Yass Valley Wind Farm Visual Impact Assessment

Summary Review of:

ERM Supplementary Landscape Visual Assessment

19 November, 2015

Viewpoint C60

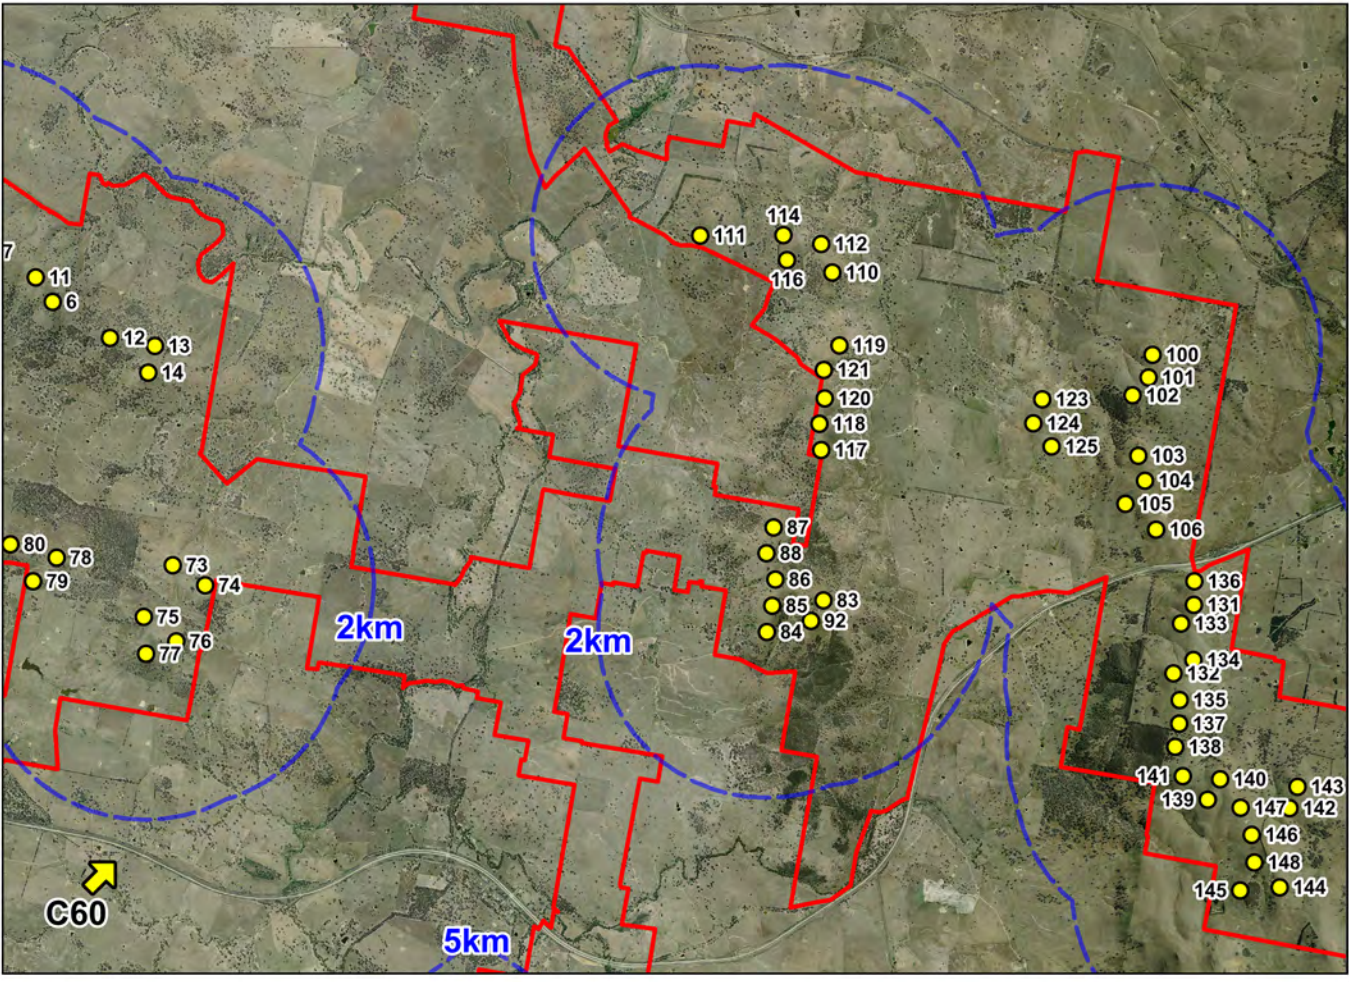
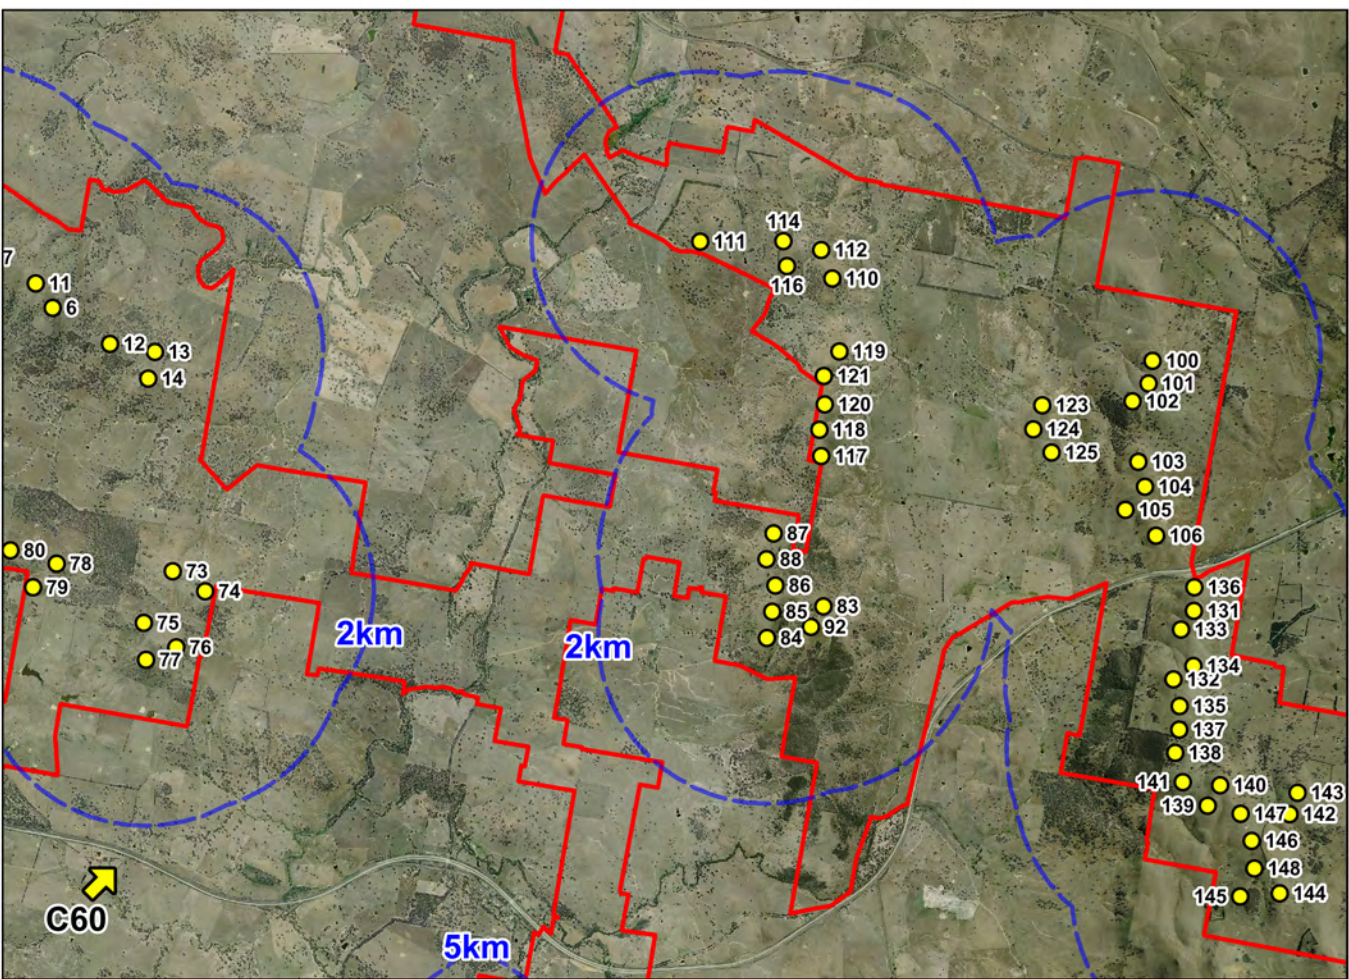
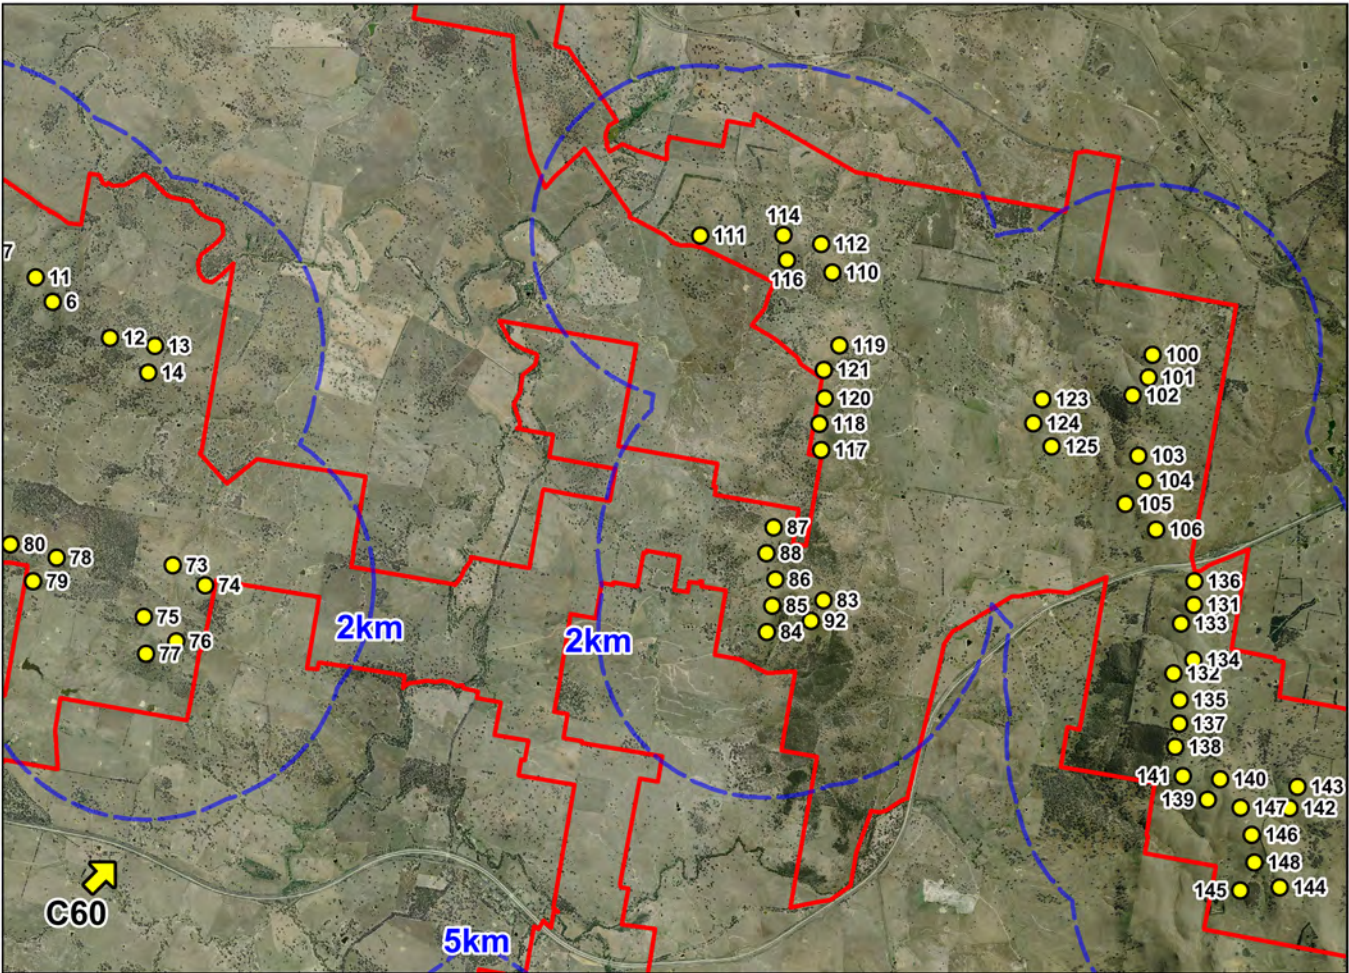
Turbines 83-87 in close proximity to Bookham require further examination and assessment. The potential impacts of Turbines 75, 76 and 77 close to a group of uninvolved residents C75, C06, C08, C60 and C41 west of Bookham require further investigation.	The Department recommends further investigation of impacts of Turbines 73, 74, 75, 76, 77 and 79 west of Bookham and further photo montages should be provided in relation to a group of non-associated houses including C75, C06, C08, C60 and C41 in this vicinity. The Assessment Report states that “should the impacts of these turbines on the Hume Highway properties be identified as unacceptable it would provide additional reason for their removal, with benefits for C67”.	The proponent confirmed that ; Three (3) receivers which were identified as involved with the wind farm project in the 2014 MDA report have been included in the current assessment as non-involved: C04, C27, C68 and; Three (3) receivers may become non-involved and have therefore been considered as non-involved in the current study: G31, M13, M32.	Turbines 73 and 74 referred to in the Assessment Report are additional to RLA's original recommendations. Additional photomontages have been provided which represent the west, centre and east of this group of residences for C06, C41 and C75. No specific additional information is provided in the proponent's response in relation to C08. We have reviewed additional photomontages in respect of C06, C41, C75, and C60 (ie residences referred to in RLA Peer Review recommendations) below.

<table><tr><th colspan="2">Sub-Table 1: Turbines Visible from residences</th></tr><tr><td>C60</td><td>74*, 75*, 76*, 77*, 145, 148</td></tr></table>

*turbines are those with which DP&E have “serious concerns” in the Assessment Report Whilst in many cases multiple turbines (as listed in the table above) are visible in the landscape from approximately 2.5km, visual impacts are moderate and acceptable in our opinion. In our opinion there is insufficient justification to remove Turbines 73, 74, 75, 76 and 77.	Sub-Table 1: Turbines Visible from residences		House Reference	Turbines visible from dwelling as shown in photomontages	C06	111, 117, 138, 145	C41	6, 9, 15, 44, 74*, 75*, 76*, 77*, 78, 79*	C60	74*, 75*, 76*, 77*, 145, 148	C75	73, 74*, 75*, 76*, 77*, 79*, 92, 132, 141	C67	West cluster only 73*, 74*, 76*, 77*, 78 and one additional turbine not labelled.
Sub-Table 1: Turbines Visible from residences																	
House Reference	Turbines visible from dwelling as shown in photomontages																
C06	111, 117, 138, 145																
C41	6, 9, 15, 44, 74*, 75*, 76*, 77*, 78, 79*																
C60	74*, 75*, 76*, 77*, 145, 148																
C75	73, 74*, 75*, 76*, 77*, 79*, 92, 132, 141																
C67	West cluster only 73*, 74*, 76*, 77*, 78 and one additional turbine not labelled.

Viewpoint C67

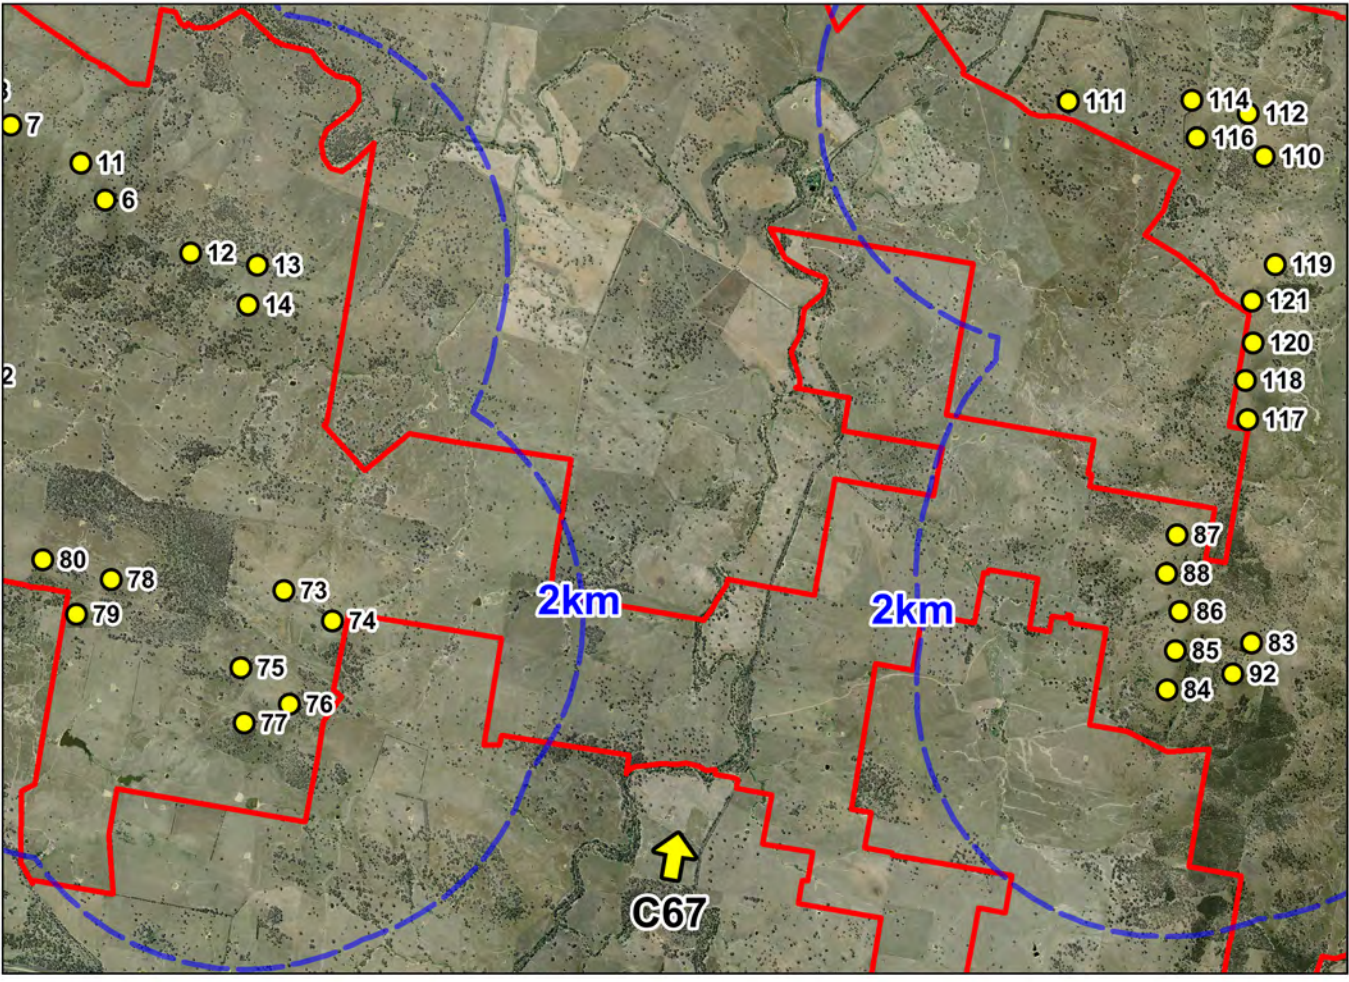
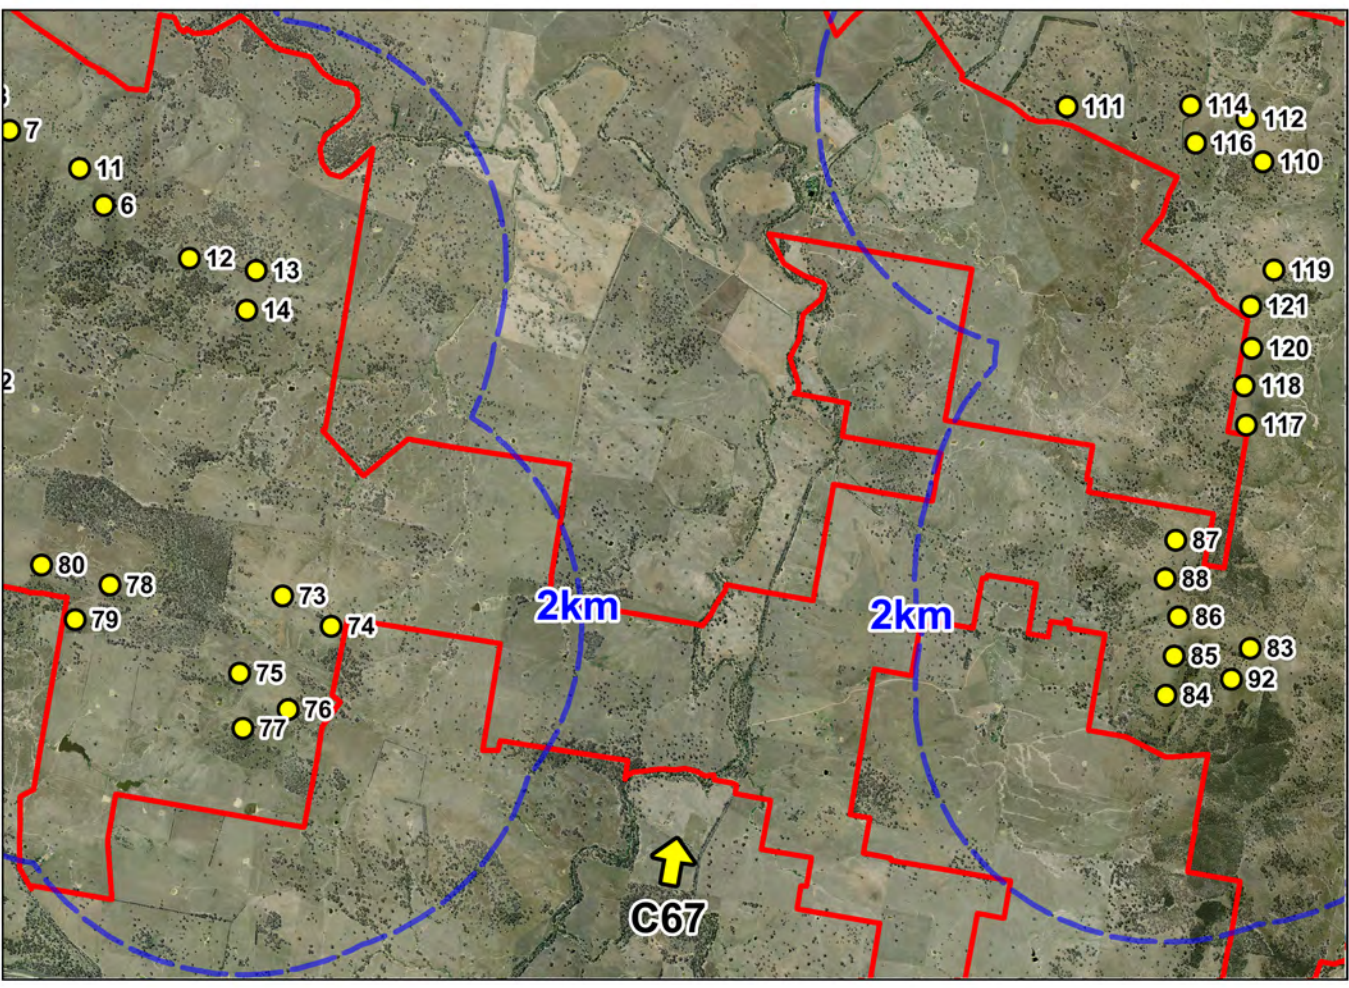
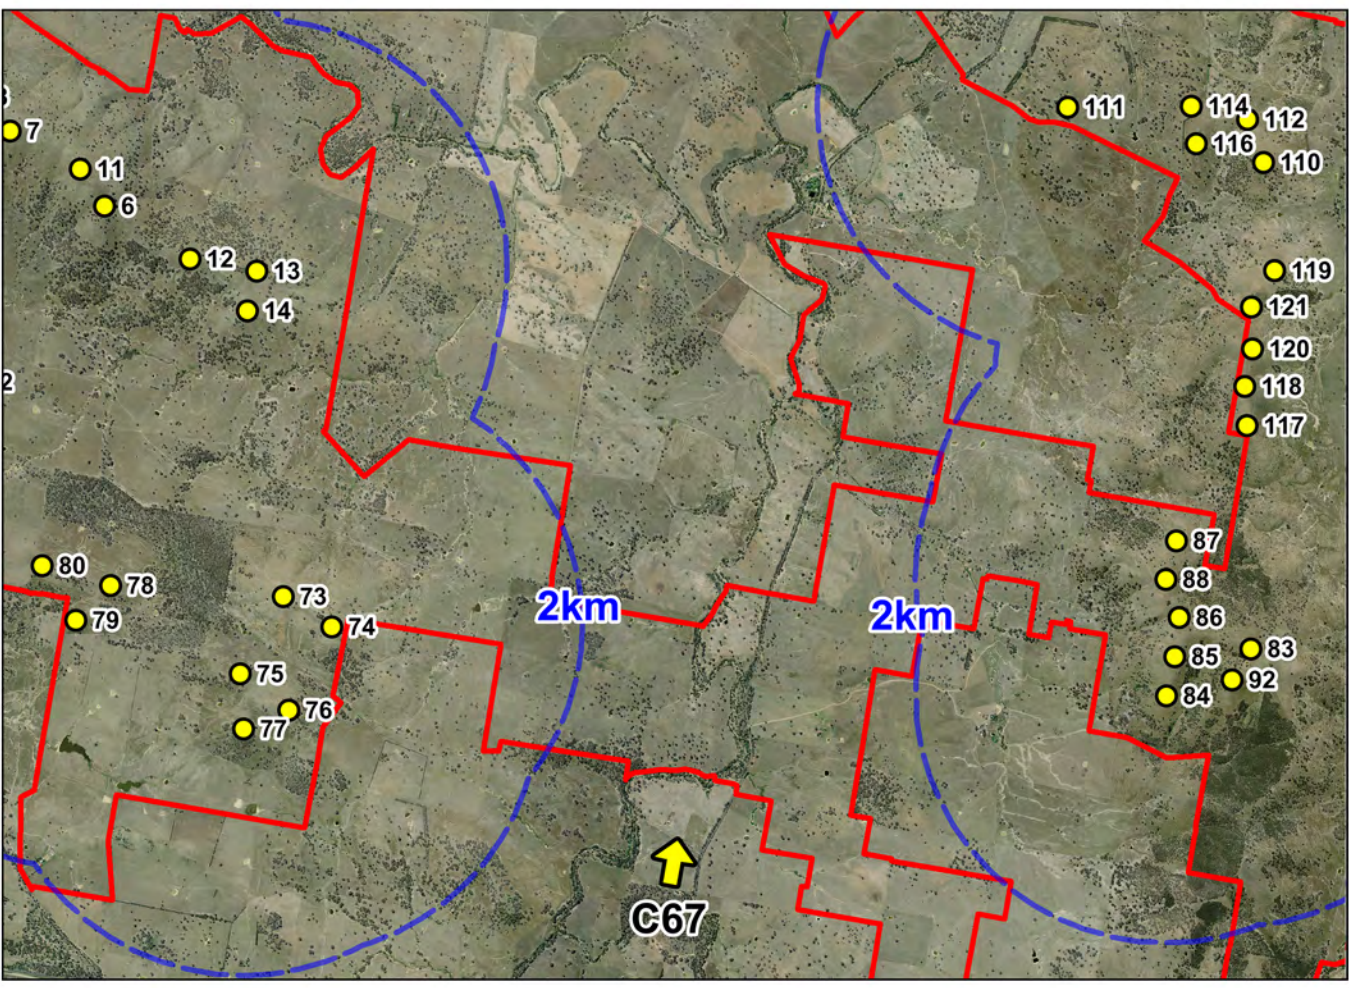
8. Removal of these turbines benefits the view from residence C67. We do not consider that further removal of turbines to benefit the view from C67 up to a distance of 3.2km, as recommended in the Assessment Report, is justified.

<table><tr><th colspan="2">Sub-Table 1: Turbines Visible from residences</th></tr><tr><td>C67</td><td>West cluster only 73*, 74*, 76*, 77*, 78 and one additional turbine not labelled.</td></tr></table>
